Peartree Hill Solar Farm

Environmental Statement Addendum Revision 2

Application Document Ref: EN010157/APP/8.2

August 2025

Revision 2

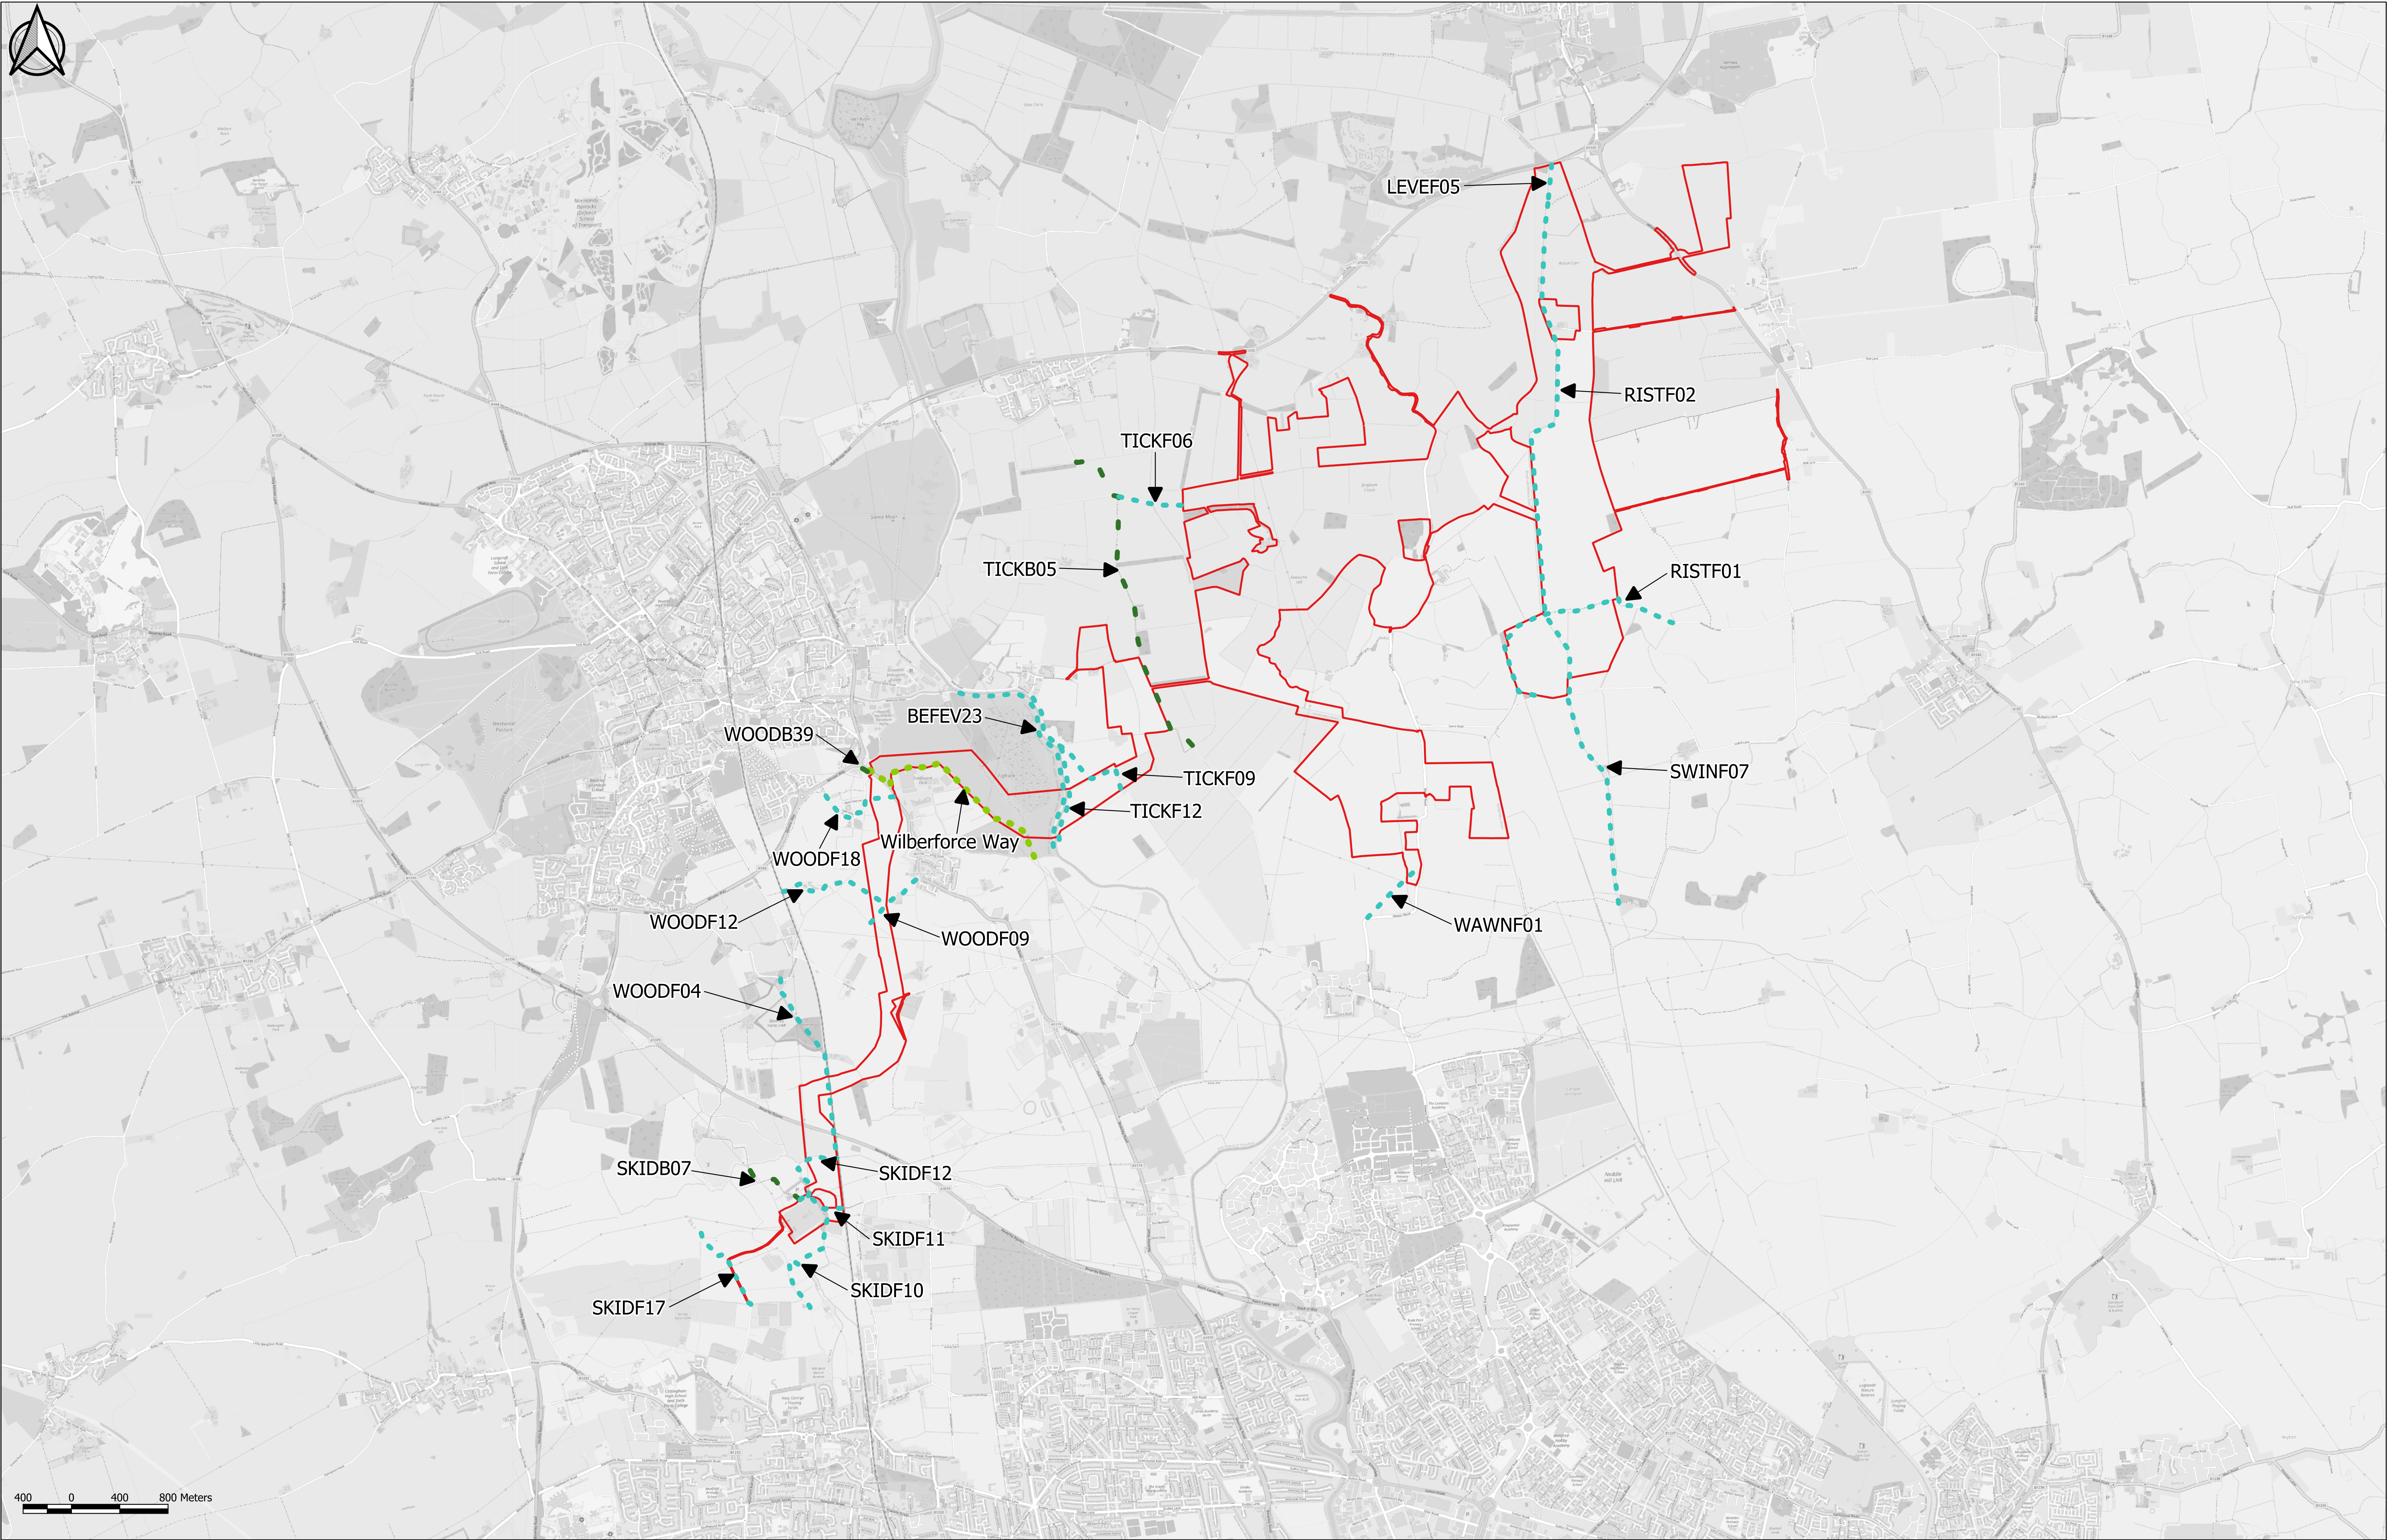
Document reference	Reason for amendment	ES Amendment July 2025
ES Volume 3, Figure 14.3: Public Rights of Way and Long Distance Paths Within and Adjacent to the Proposed Development [APP-091]	Figure 14.3 requires amendment to reflect the removal of plots 10-4, 10-5 and 10-6 as part of change/correction 2.	
ES Volume 3, Figure 14.4: Link Sensitivity [APP-092]	Figure 14.4 requires amendment to reflect the removal of plots 10-4, 10-5 and 10-6 as part of change/correction 2.	
ES Volume 3, Figure 15.1: Other Existing and/or Approved Development [APP-093]	Figure 15.1 requires amendment to reflect the removal of plots 10-4, 10-5 and 10-6 as part of change/correction 2.
